Consultation Response from KC, Lead Local Flood Authority
2023/91431 land south of, The Lodge and north of Church Lane, Linthwaite, Huddersfield
Discharge of conditions 7 (internal roads), 8 (Church Lane crossing), 12 (electric vehicle charging), 13 (waste storage and collection), 17 (attenuation basin), 18 (flood routing), 23 (crime prevention) and 32 (landscaping) of previous permission 2021/91571 for erection of residential development for 125 dwellings
Date Responded: 15th July 2023 Responding Officer: Paul Farndale Responding Ref:

Condition 23 – Flood Routing

Client: The Casey Group Ltd	Project: BROADOAK FARM, LINTWAITE	Drawn: AL	Checked: SA	Approved: ME	Date: 23/12/20
Issue: PLANNING	Title: GENERAL ARRANGEMENT	Dwg No: UG_721_LAN_GA_DRW_01	Scale @ A1: 1:500	Revision: P13

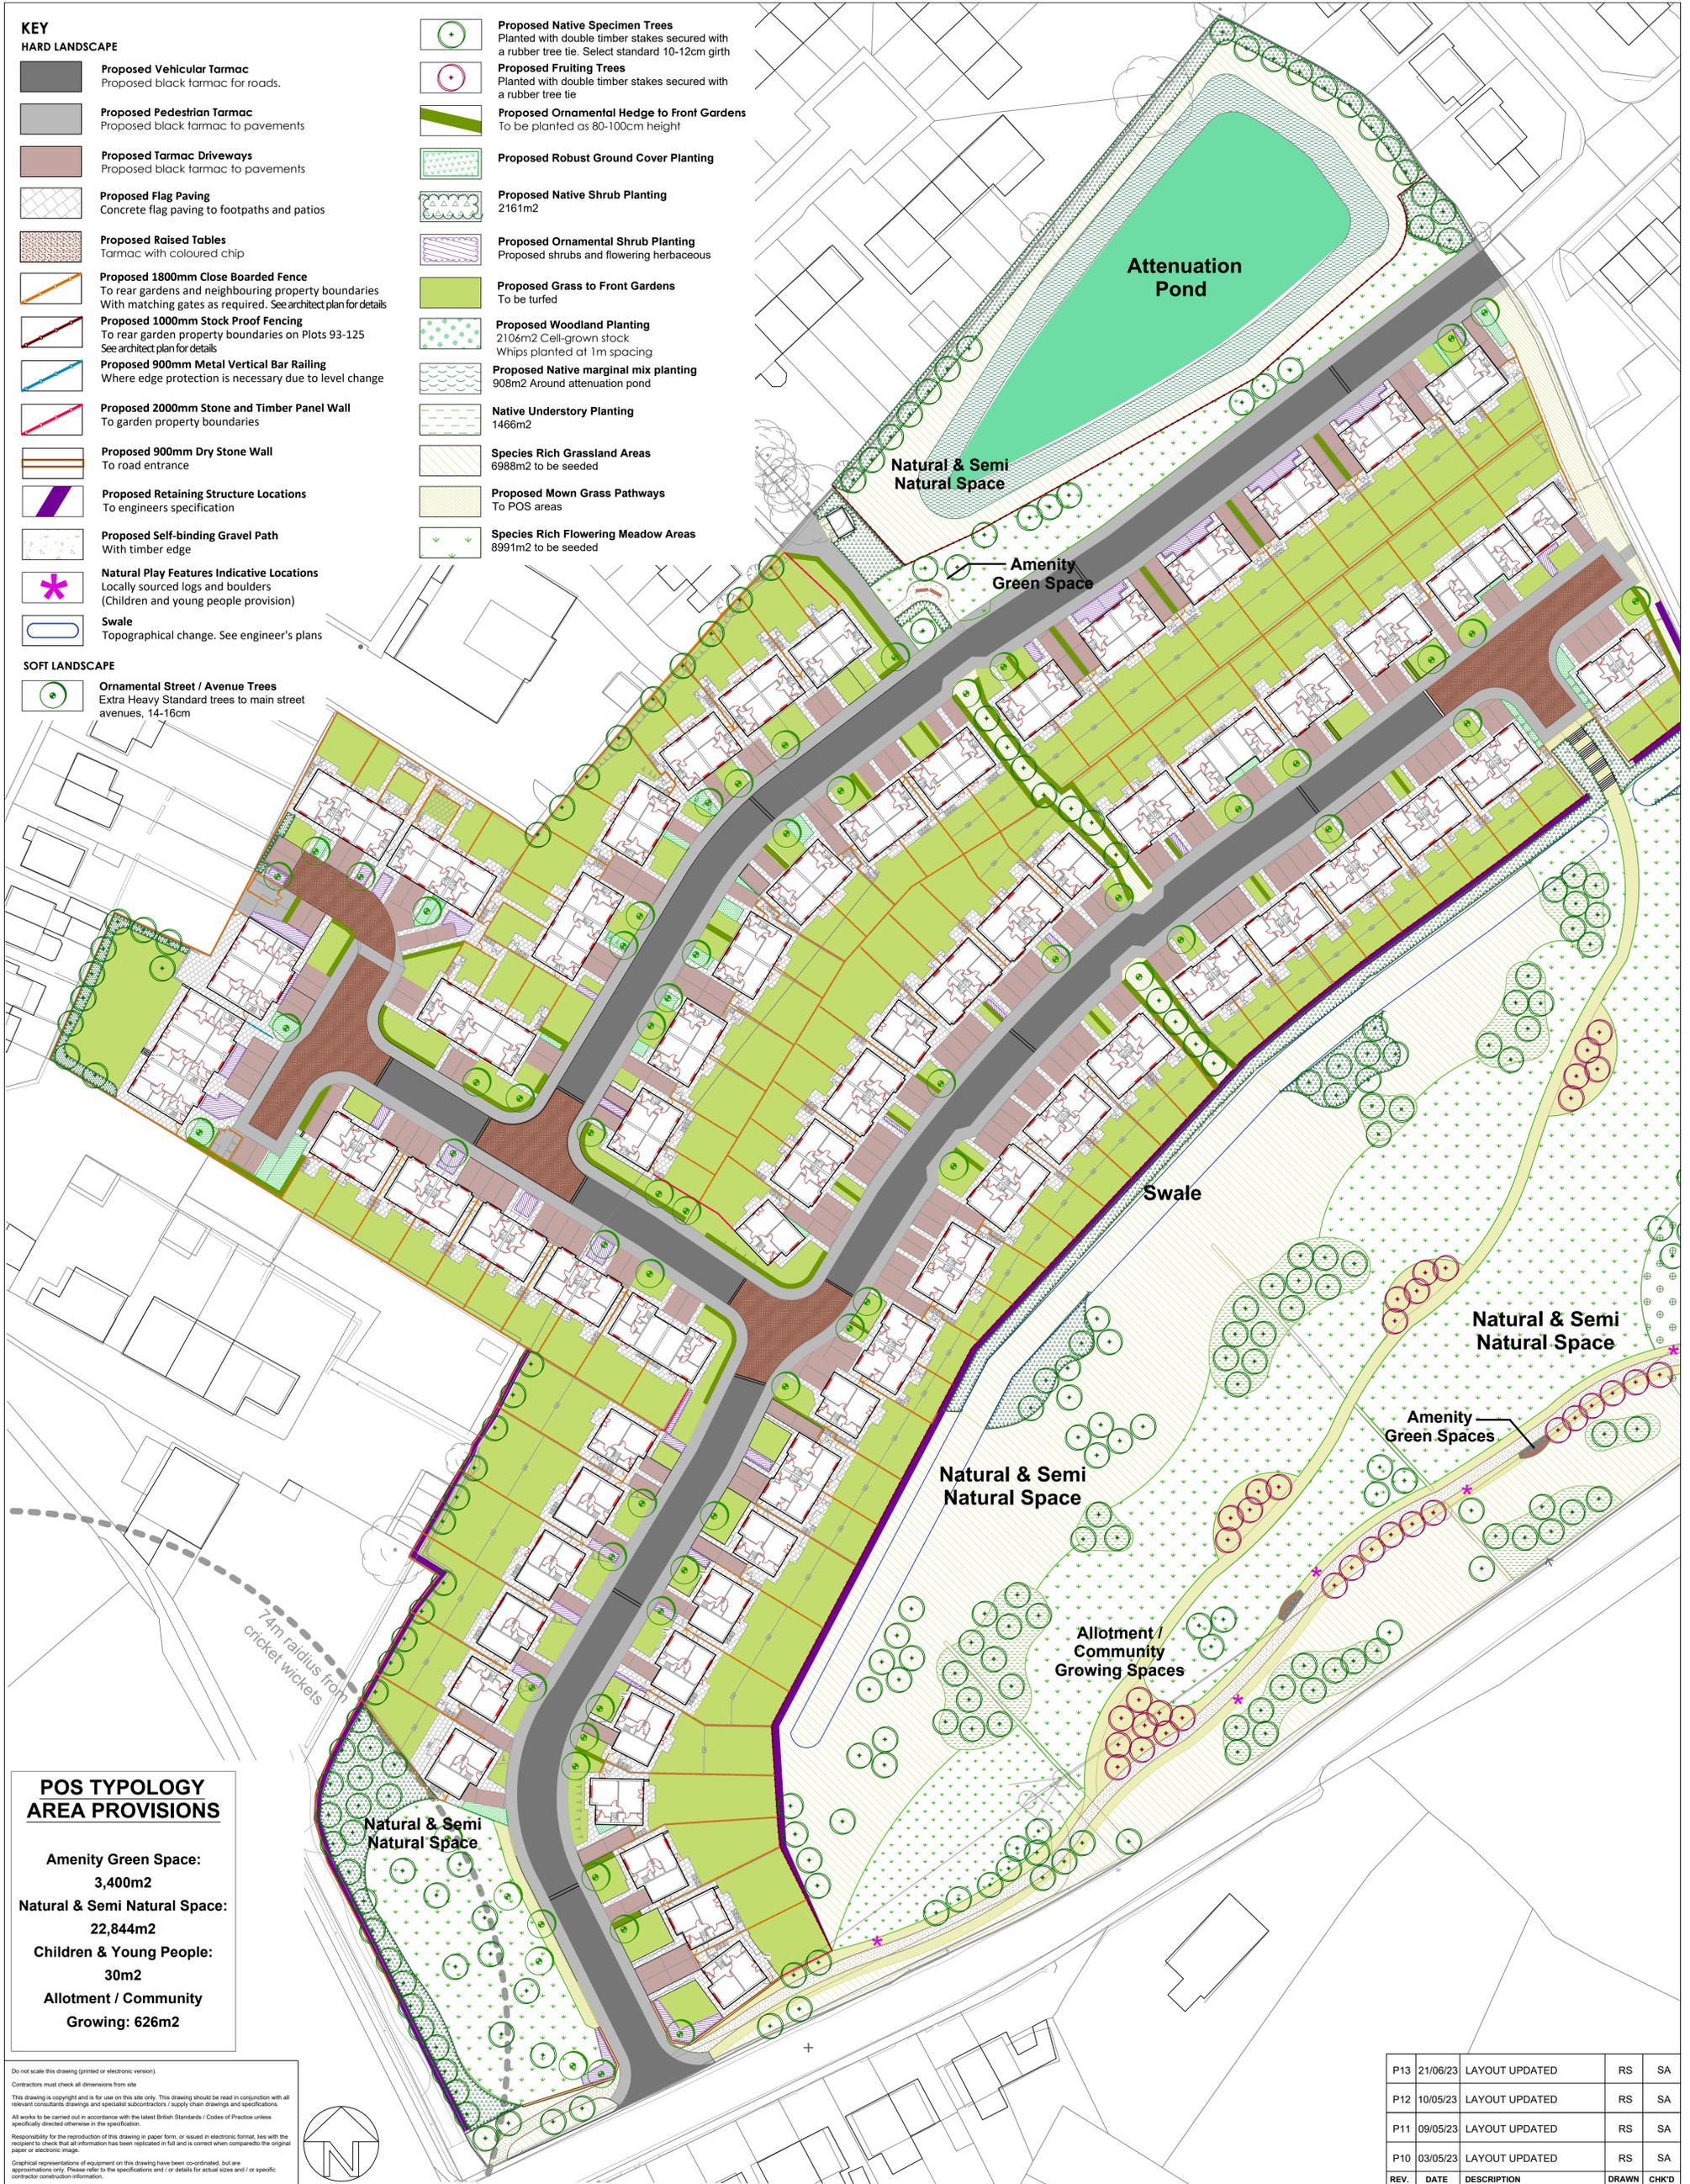
Swales for flood routing of cascading water from grassed slopes are now included on landscaped drawings.

We can recommend that this condition can be discharged.
